Application No: AW/197/20/PL

Recommendation Report for Planning Permission

LOCATION: The Former Ship Inn
Aldwick Street
Aldwick
PO21 3AP

PROPOSAL: Variation of conditions 8-concerning hours of deliveries & 10- types of vehicles making deliveries following AW/211/14/PL. This application is in CIL Zone 4 (Zero Rated) as 'other development'.

Client
Surplus Property Investments
 Project
The Former Ship Inn, Aldwick Street, Bognor Regis. PO21 3AP
 Title
Highway details with Vehicle Tracking : Articulated Delivery Vehicles

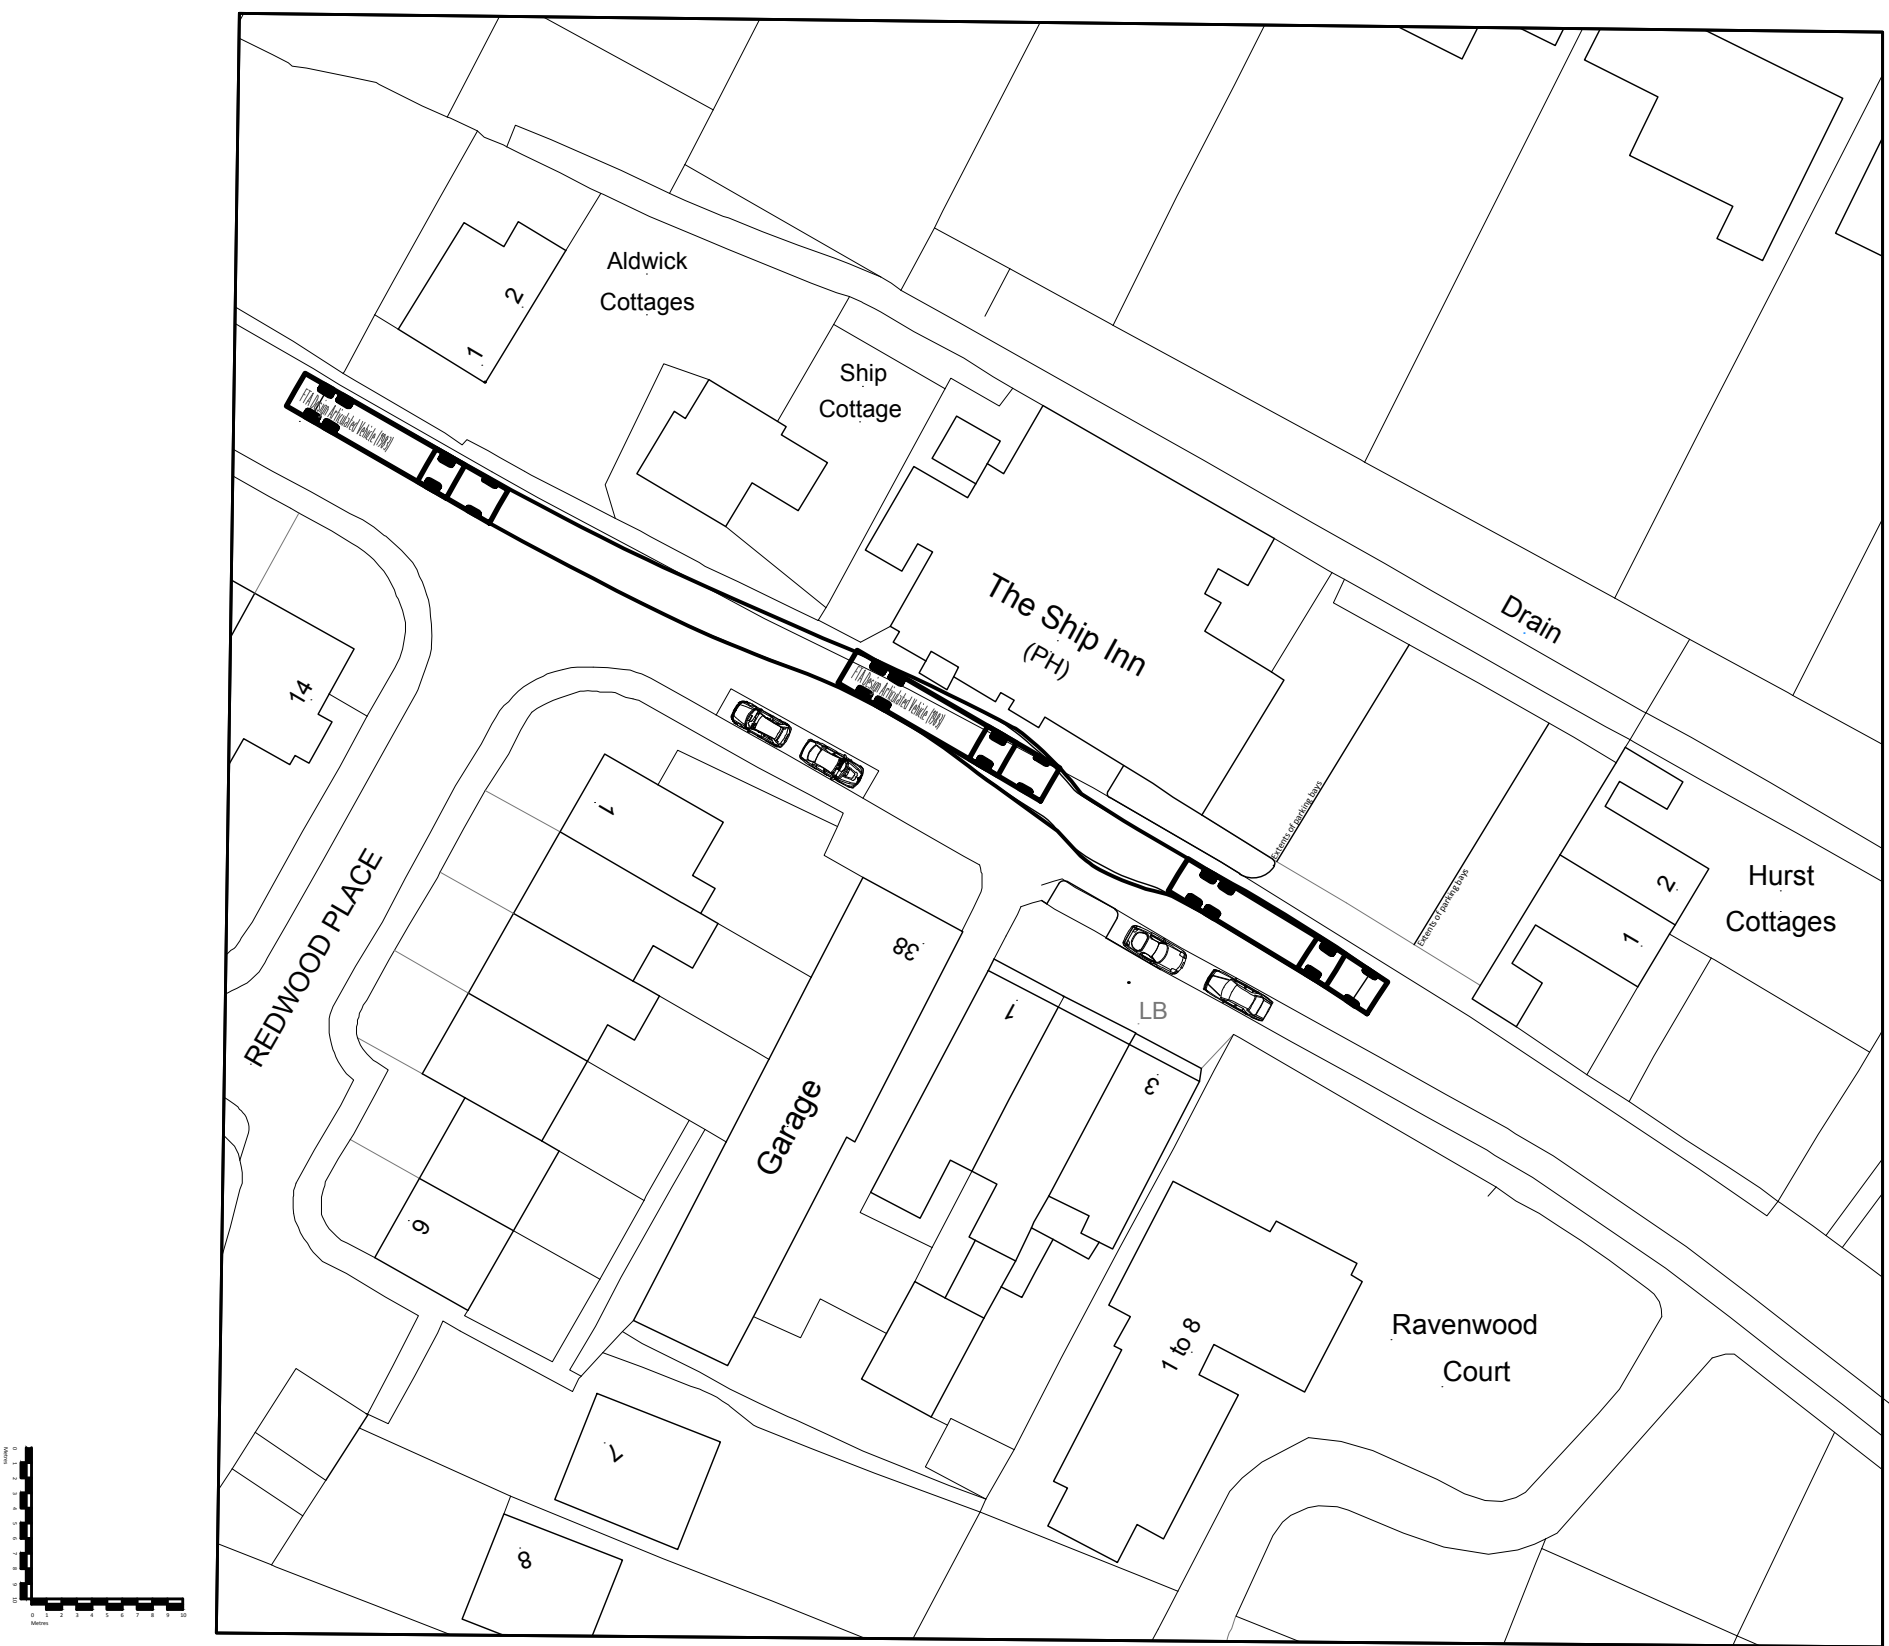
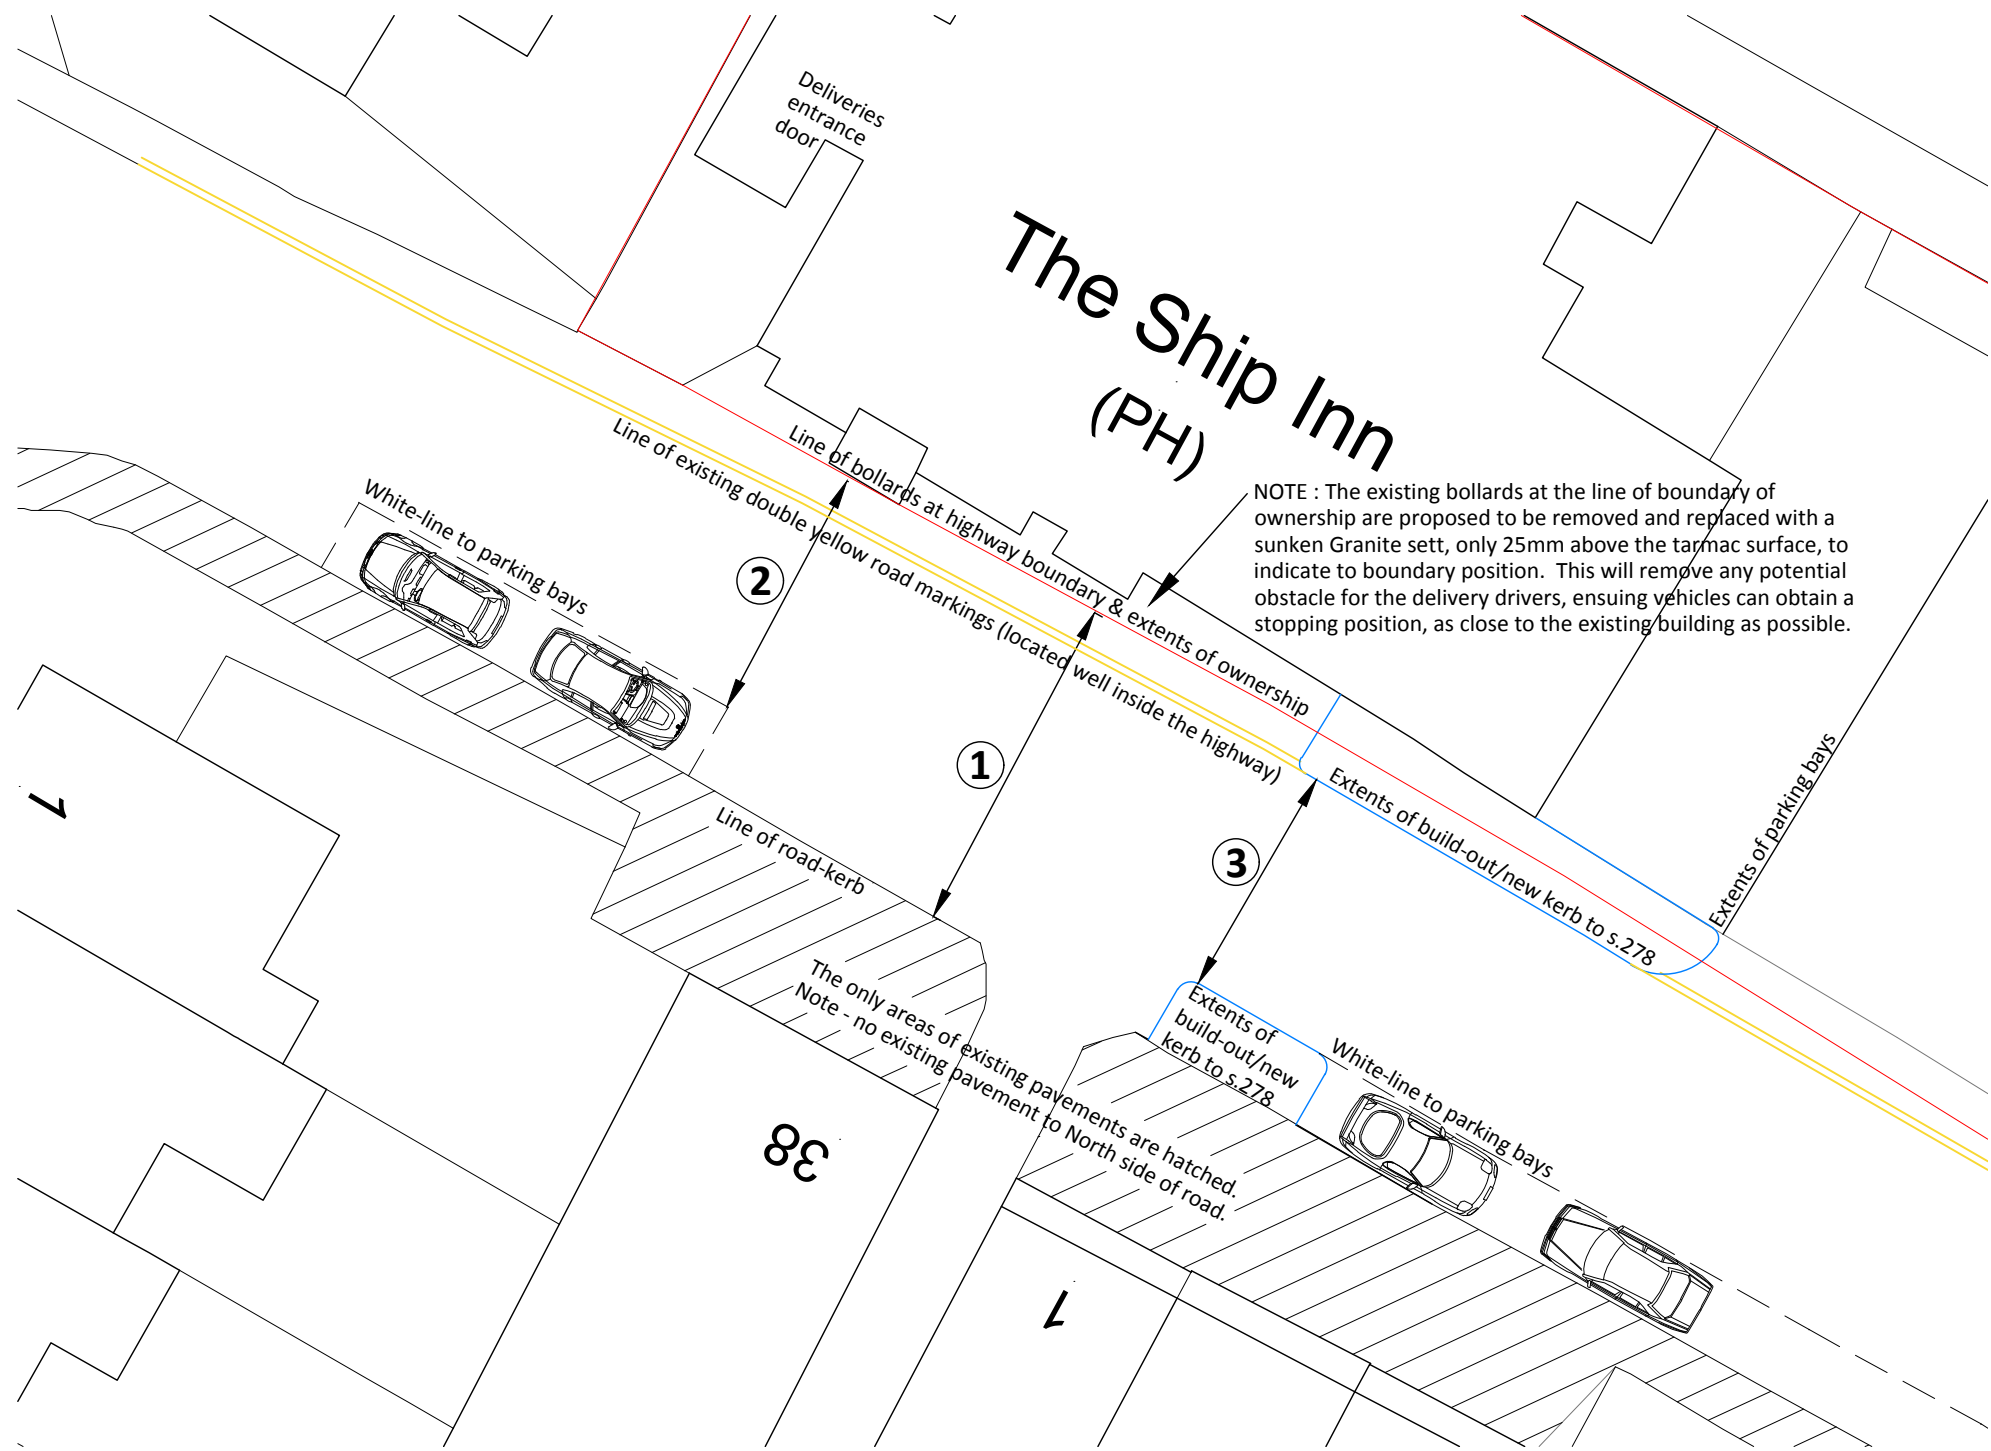
- Based on the highway plan which shows the dimension of the road at three points, it is confirmed that a 2.6m wide articulated lorry parked on the highway would still leave 3.6m available for one vehicle to pass safely;
